From: Tim Townsend [REDACTED]
Sent: 04 January 2018 09:41
To: Planning.Responses
Cc: Derek Whittington; Richard Temple
Subject: AL/115/17/OUT - Proposed development of 55 homes - Land at Wings Nursery, A29 Lidsey Road, Woodgate - WSCC Highways response dated 4th January 2018

DATE: 4th January 2018

SUBJECT: AL/115/17/OUT - Outline application with some matters reserved for the erection of 55No. dwellings, sustainable drainage measures, public open space, children's play area, landscaping & all other associated works. This application is a Departure from the Development Plan.

LOCATION: Wings Nursery, Lidsey Road, Aldingbourne, PO20 3SU.

Figure 2.6: PIA Distribution

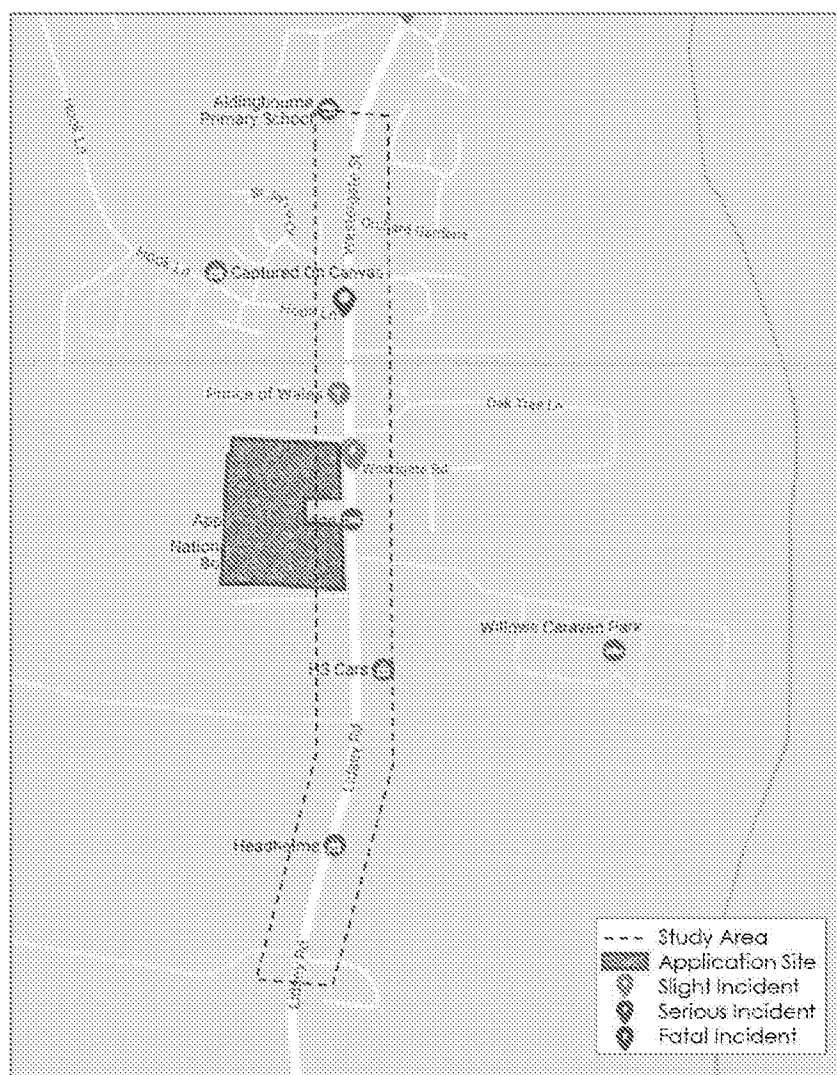
Three PIAs have occurred along this stretch of the A29 using data taken between 2009 and 2014. It is not known why more recent data hasn't been used. Applicants are required to provide the most up-to-date records. From interrogation of the three recorded incidents in the documentation provided so far, two of these occurred at the junction of Woodgate Road with Lidsey Road with a further (serious) accident at the junction of Hook Lane with Lidsey Road north of the railway crossing. Both of the Woodgate/Lidsey Road accidents resulted in slight injuries being recorded. It should be noted that one of these accidents involved a vehicle travelling on the offside of a stationary queue of traffic as a result of the level crossing being closed in order to turn into Woodgate Road. This supports the Highway Authority's concerns that drivers may experience frustration caused by the queueing caused by the railway crossing closures and possibly undertake manoeuvres that would otherwise not be attempted.

RGP Swept Path Analysis

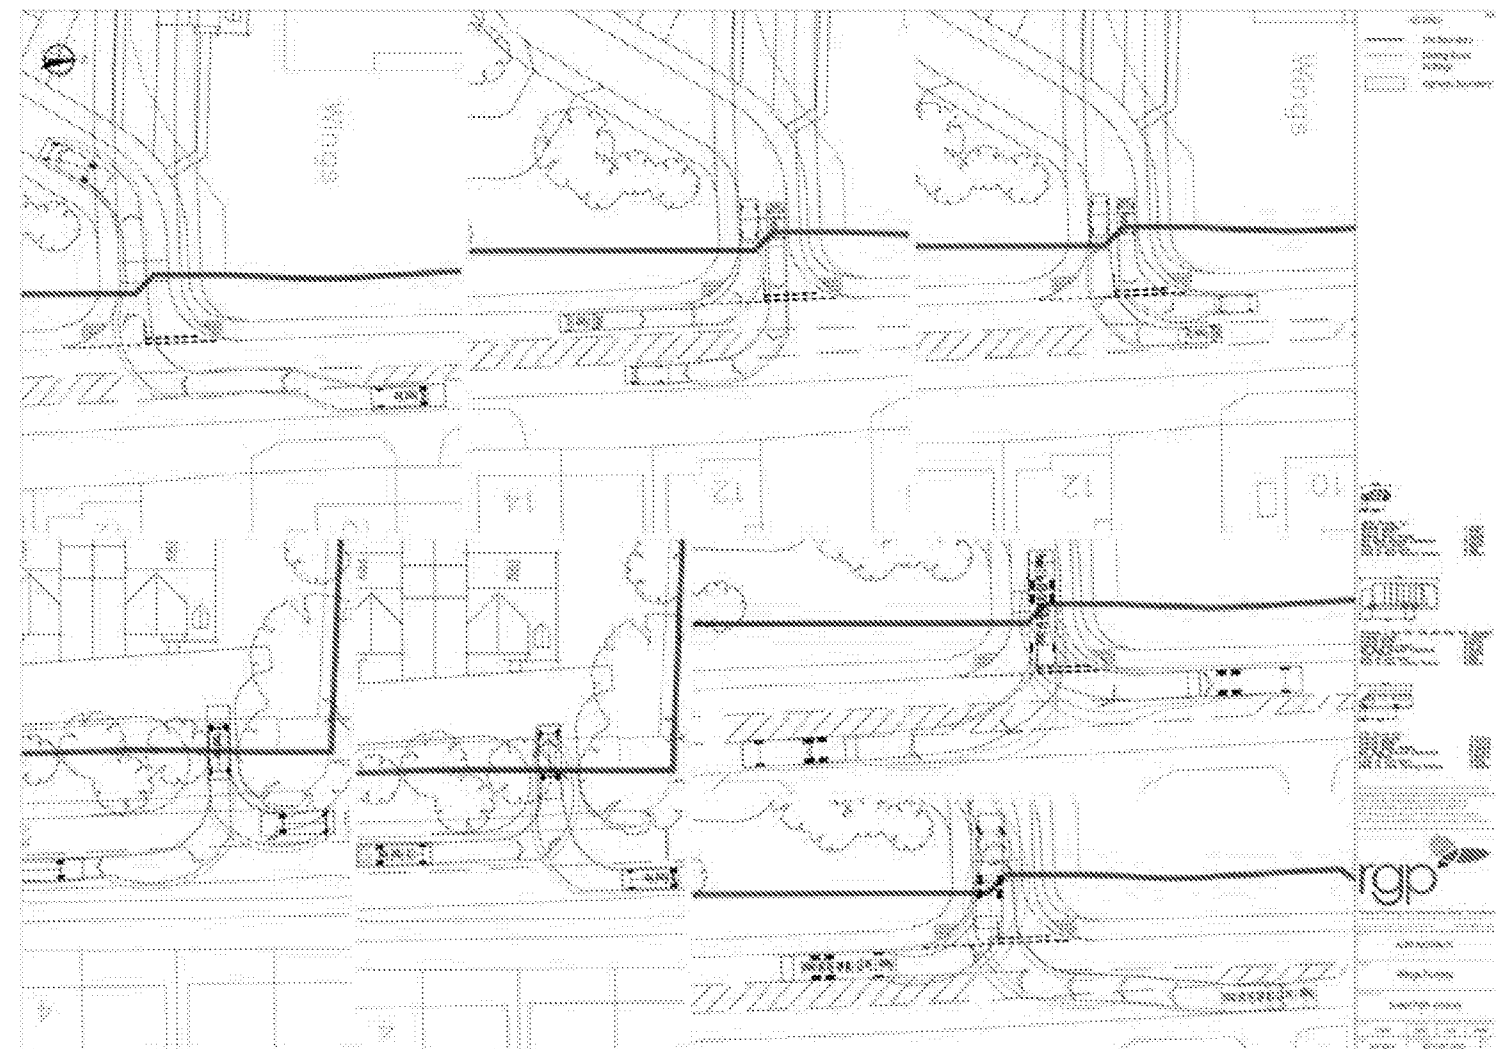
The Highway Authority has reviewed the information provided (including swept-path diagrams of vehicles entering and leaving the junction). Based on that provided, four concerns have been identified. Namely:

2. Large vehicles are required to oversail the centreline of the new access road. If they attempt to do this during busy period when traffic might be blocked because of the queueing extending back from the railway crossing, such vehicles could end-up finding their paths blocked, thereby leading to potential blocking on the A29.
